Input to SEARs SSD 6666 MOD 1 – Cessnock City Council

Hydro Kurri Kurri Aluminium Smelter Remediation Mod 1- Temporary Water Treatment Plant (SSD 6666)
Comment on the Secretary's Environmental Assessment Requirements (SEARs)

**State Significant Development 6660 – Modification 1 – On Site Water Treatment Plant –
Hydro Aluminium Smelter, Hart Road, Loxford**

I refer to your email dated 3 February 2021 requesting comment from the Environment Protection Authority (**EPA**) about Modification 1 to SSD 6666 (**the Modification**). The Modification seeks to enable the construction and operation of an onsite Temporary Water Treatment system and associated infrastructure; and to enable discharge of the treated leachate to the existing water management system.

**Figure 2 |** Proposed location of leachate management infrastructure

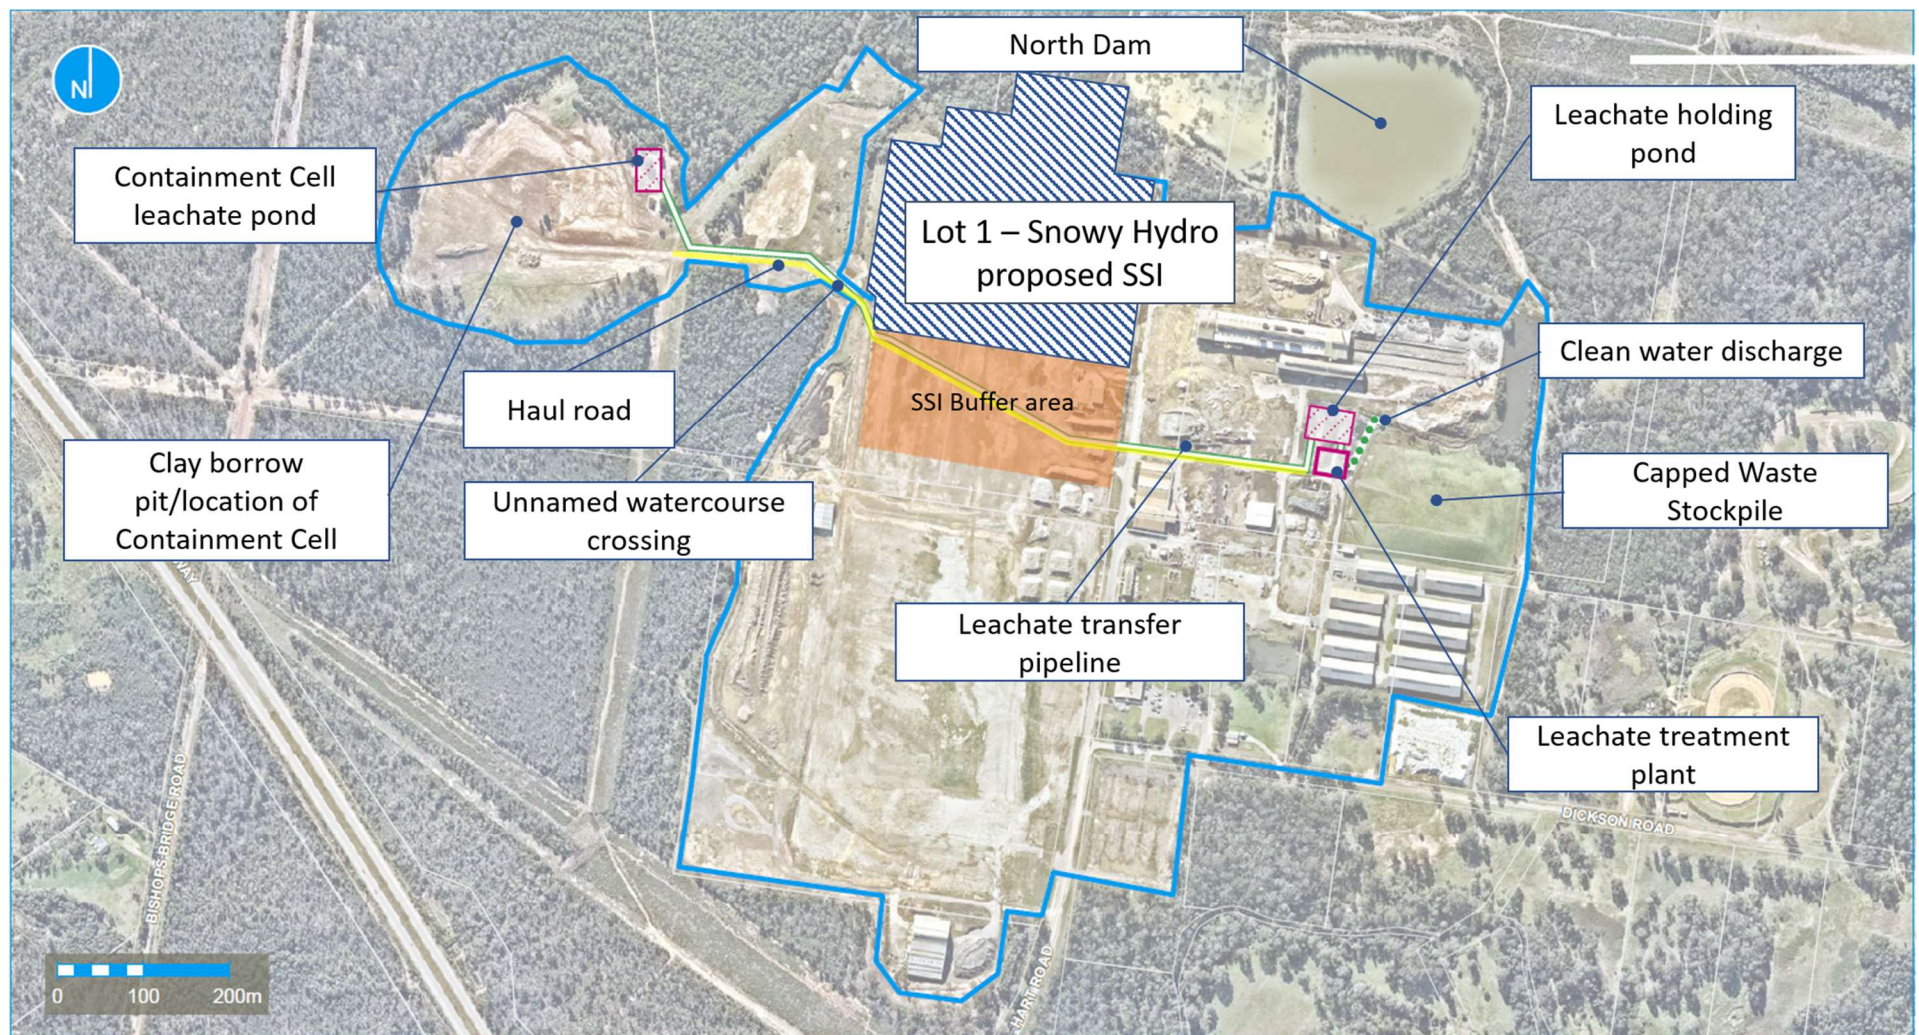
Leachate within the Containment Cell Leachate Pond would be pumped out and transported to the Leachate Holding Pond via a HDPE pipe when:

A surface-laid 100 mm diameter high-density polyethylene (HDPE) pipe would be installed to transfer leachate from the Containment Cell Leachate Pond to the Leachate Holding Pond. The plant is designed to treat and discharge a maximum of 2,400 kL/month.

The containment cell leachate pond and leachate holding pond do not appear to have been designed using a water balance for the operations. Instead it appears to be event based. It is not clear that the leachate containment and treatment system have enough capacity based on the limited information provided.

Whilst contingencies exist to truck the leachate from the site when the system is not able to contain/process the excess leachate; the system should be designed using a water balance for the proposed operations in accordance with the *Environmental Guidelines Solid Waste Landfills (2016)* and details provided on any anticipated shortfall for onsite containment and treatment.

The SSD 6666 Modification report outlines that “*the Leachate Holding Pond is to be constructed using validated fill material sourced from the Smelter Site and lined with 2 mm HDPE lining to contain the leachate.*”

The limited details provided for the design and construction of the leachate holding pond are not adequate to assess the capacity to contain and manage the leachate generated.

The transfer pipe is to be constructed of 100 mm diameter HDPE piping and would be butt welded and surface laid. Where the pipeline is required to cross an access road it would be installed under the road. Where the pipe traverses the unnamed watercourse, it would be double skinned. The proponent has outlined that the integrity of the pipe will be checked weekly.

However, the transfer pipe should be pressure tested prior to commissioning to verify that there are no leaks.

- Leachate storage (design, construction and operation) be consistent with the technical specifications outlined in the *Environmental Guidelines Solid Waste Landfills (2016)*
- Before major construction works occur, the proponent prepares a Construction Quality Assurance Plan. This must set out the proposed testing, inspection and other verification procedures to be implemented during construction of the leachate containment works.
- Following construction, the occupier must prepare a Construction Quality Assurance Report on the quality assurance that was implemented to ensure that the works comply with the approved designs and specifications.
